Enquiries to	Samuel Coleman	My reference	6/3/1/485
Direct Line	0370 779 0358	Your reference	_____
Date	2 <sup>nd</sup> September 2021	Email	Samuel.coleman@hants.gov.uk

### Proposed single dwelling with access from A30 at Nately Scures – Pre-application Advice

Samuel Coleman  
Transport Planner – Highways Development Planning

DRAWING No: ITB16633-GA-004 REV: B

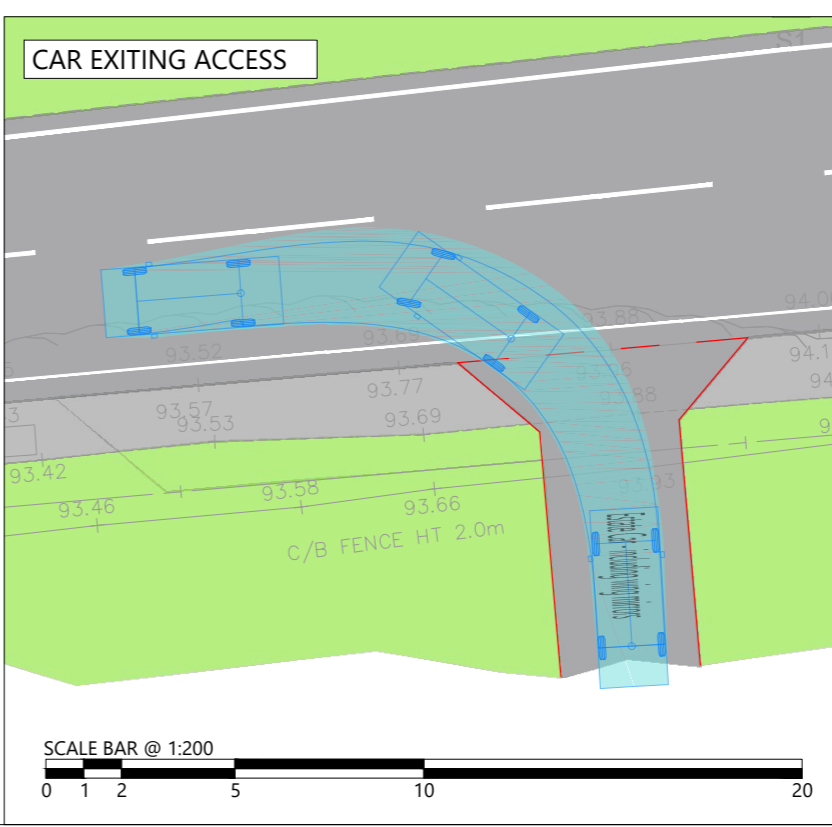
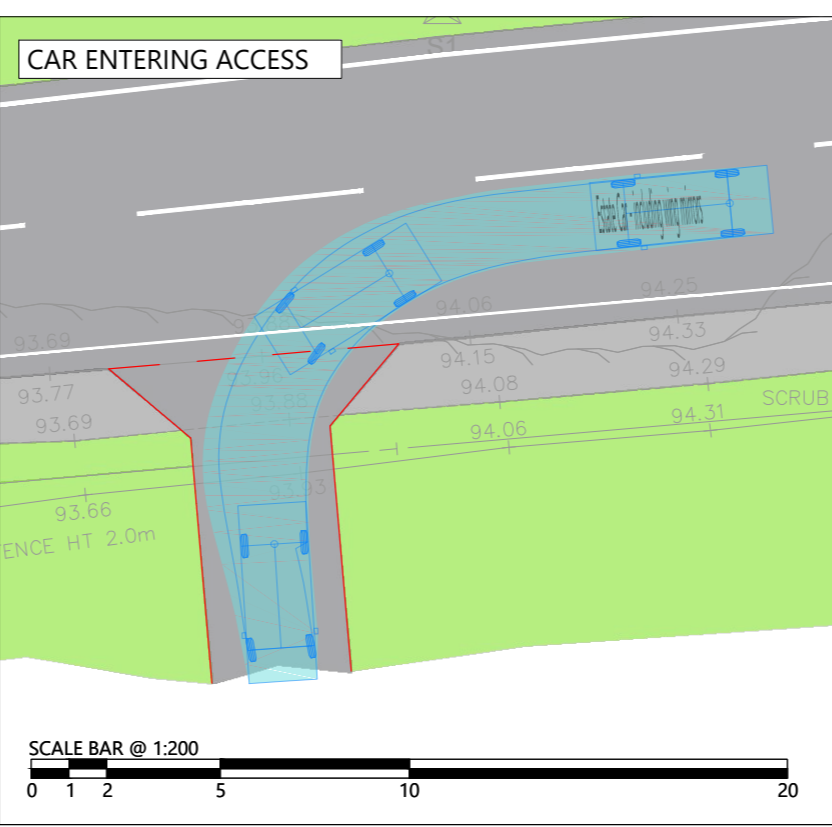
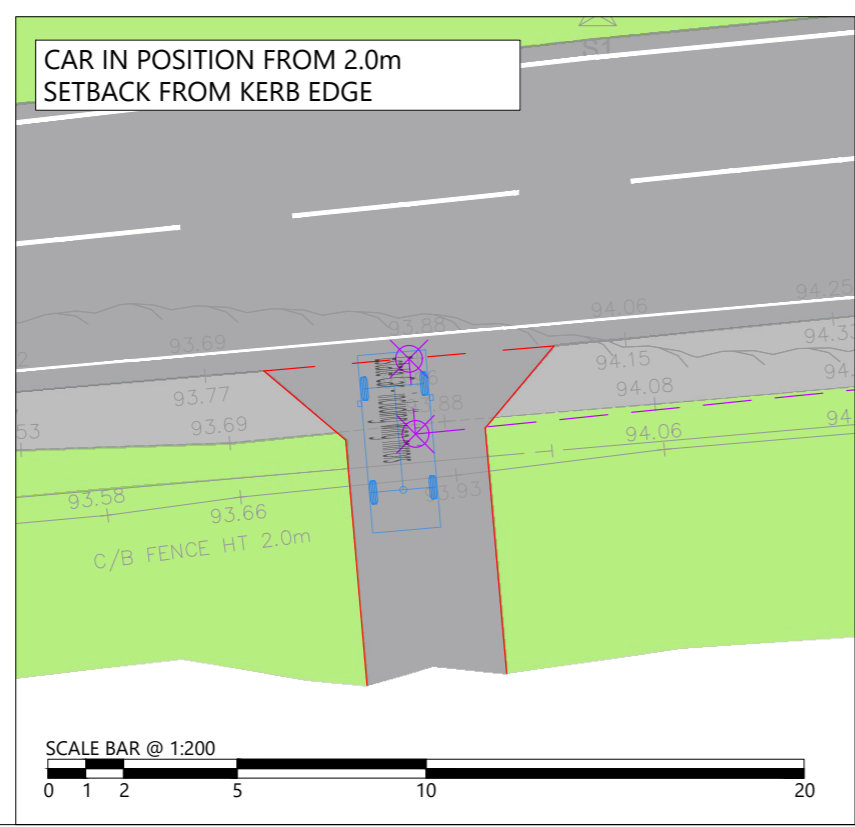
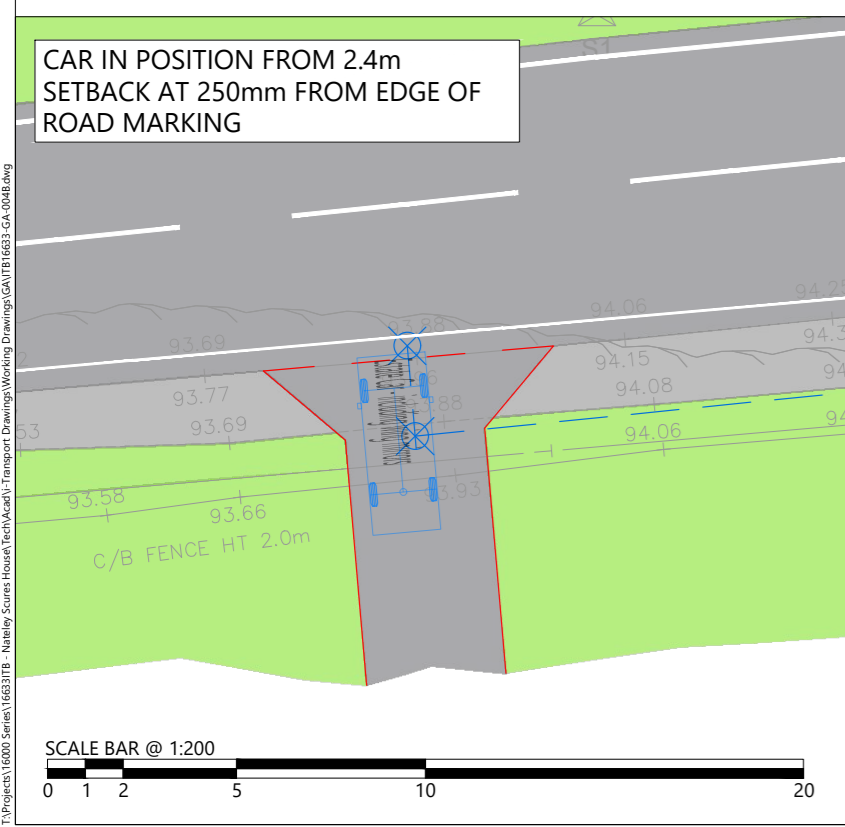
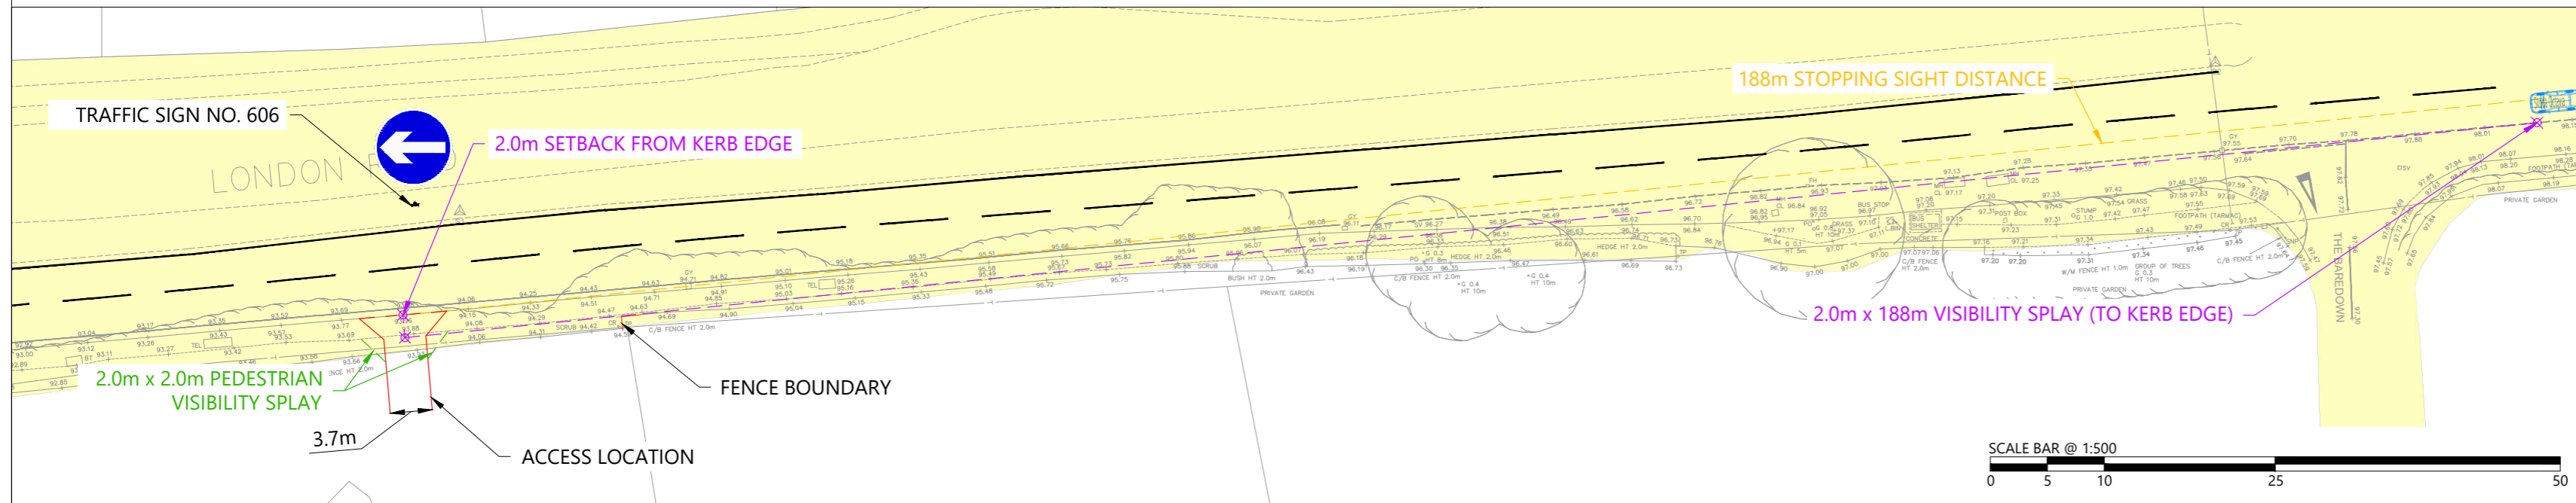
To achieve the required 2.4m x-distance the measurement would need to be taken from a 250mm setback from the 'edge of road' markings. This is the line which separates the carriageway from the hard strip as supported by Note 3 of Figure 3.4 of CD123 of the DMRB. I can confirm that the Hampshire County Council Chief Engineer has reviewed this x-distance arrangement and it is acceptable for this location and proposal.

The visibility splays of 2.4m x 188m would need to be provided on land under the applicants control or highway which the highway boundary information from Hampshire County Council shows to be the case.
